From: sally henderson [REDACTED]
Sent: 19 July 2017 11:30
To: Andrew Wood
Cc: Juan Baeza
Subject: FG 198/16/PL

Objection

I reiterate my previous 2 objections and add the following comments in response to the revised plans which now show additional parking spaces in the underground car park and 1 west facing window has been deleted.

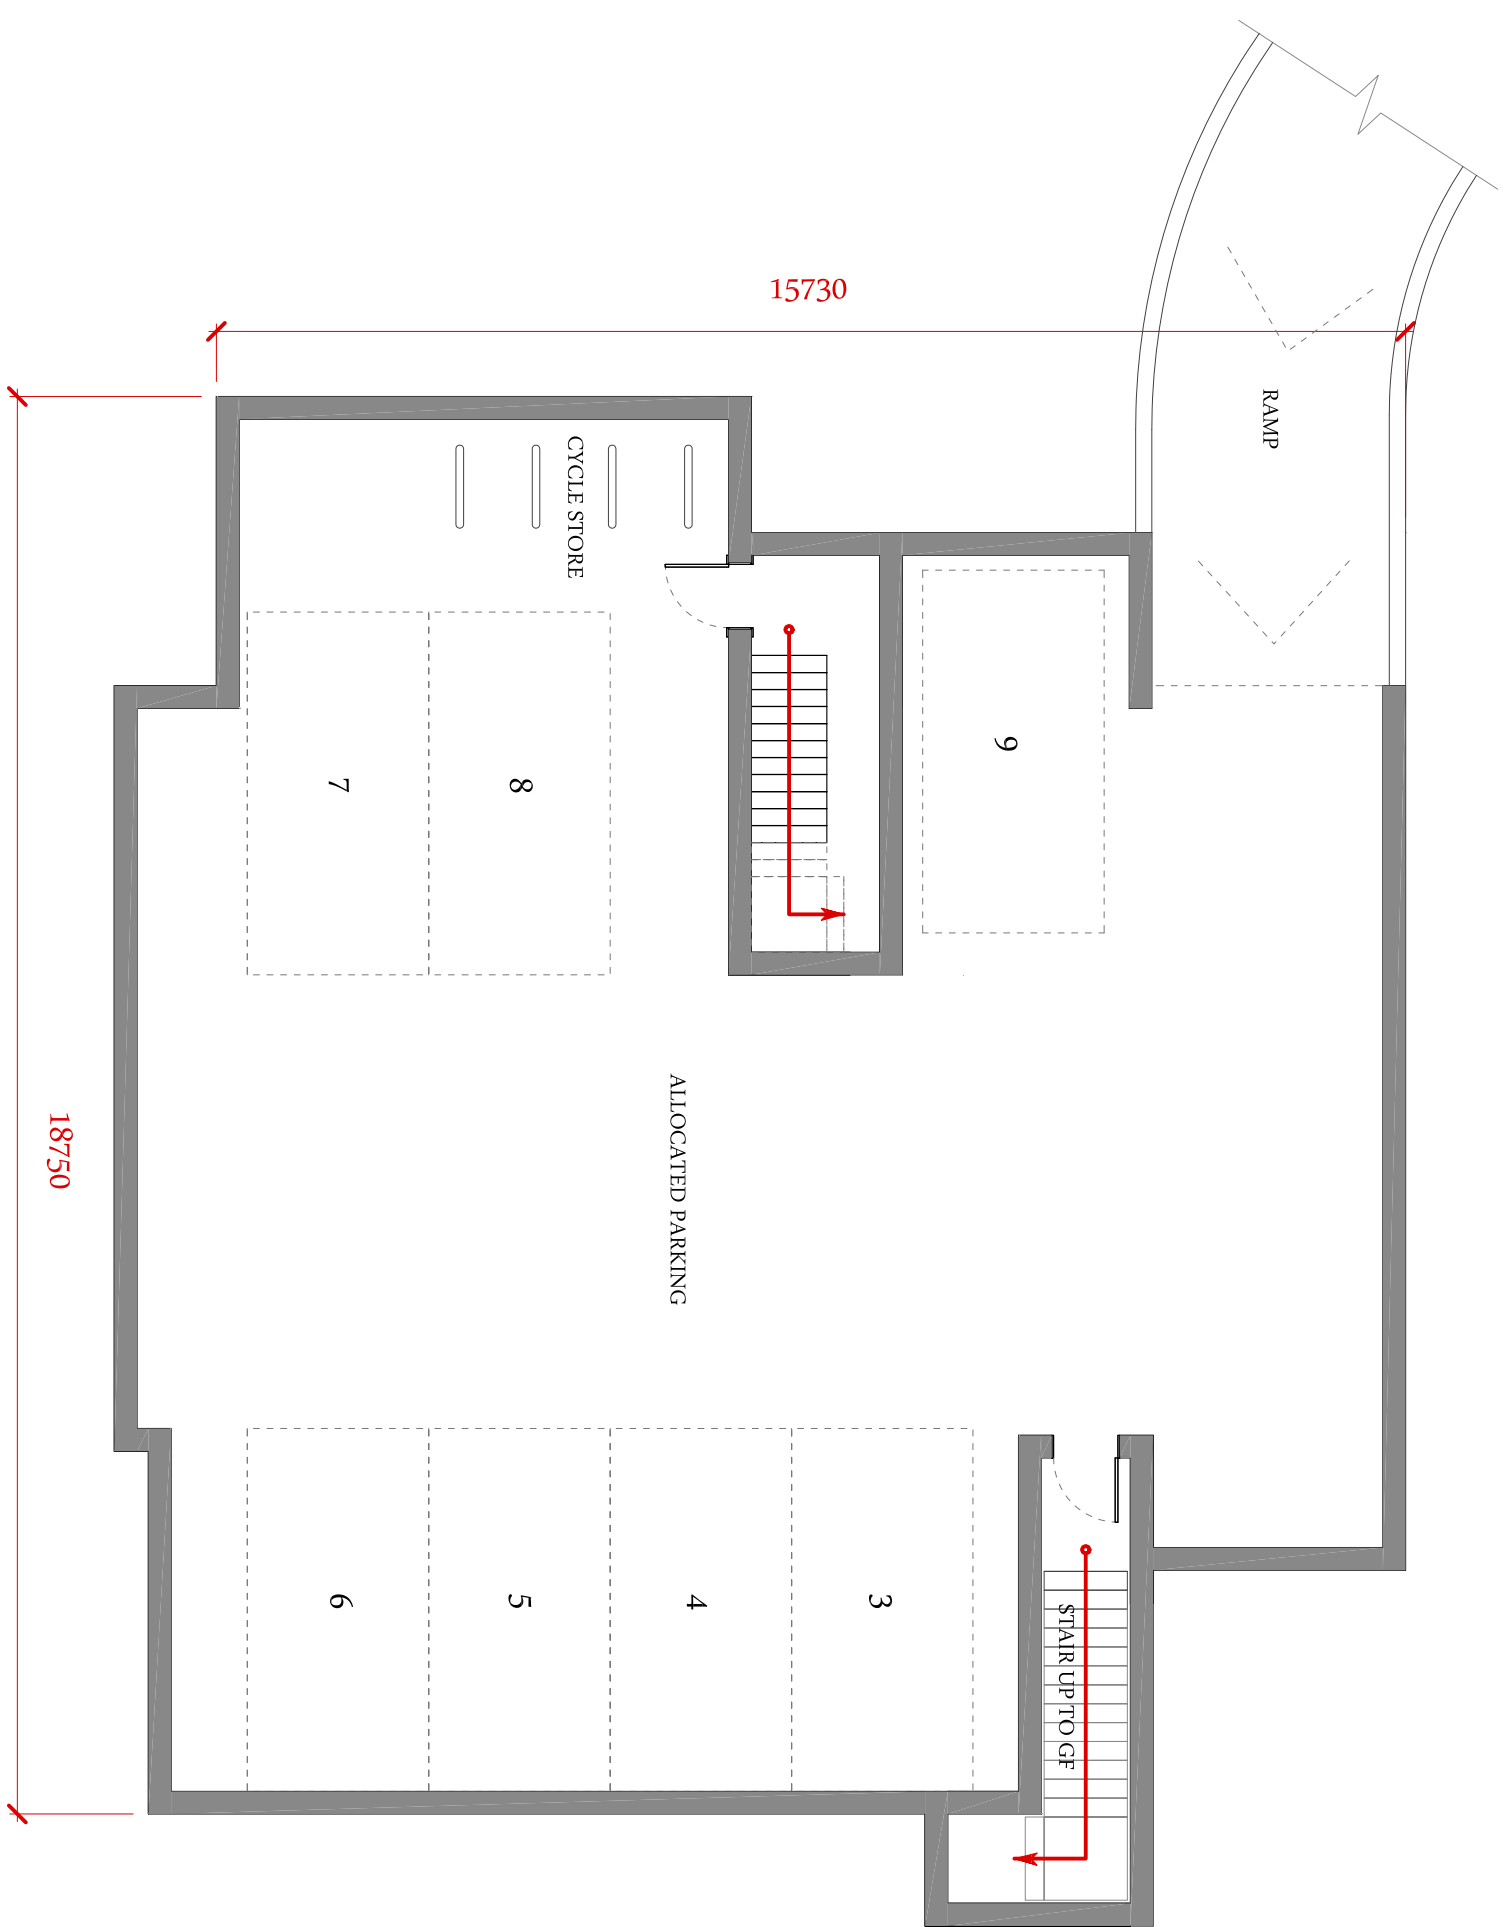
The fact that the developer shows 10 windows as obscure acknowledges this. Almost the entire Western elevation, including windows to 2 master bedrooms and the living area to 1 flat, are obscure.

In relation to the obscure windows, no level of obscurity has been proposed or proposed to be conditioned. This would make any proposal or condition meaningless at protecting our privacy since Pilkington have 5 levels of obscurity and anything below a 5 still gives those on both sides of the glass a lack of privacy. A level 5 / satin white obscurity would be required for any benefit to be provided by the condition as well as all of these windows being fixed shut to prevent overlooking from an open window.

The developer's plans show the ground floor West facing windows as obscure and yet the planner is not minded to condition this – the developer is acknowledging the issues of overlooking, overbearing and proximity of the huge number of windows to us, why will the council not enforce the proposed mitigations to this ?
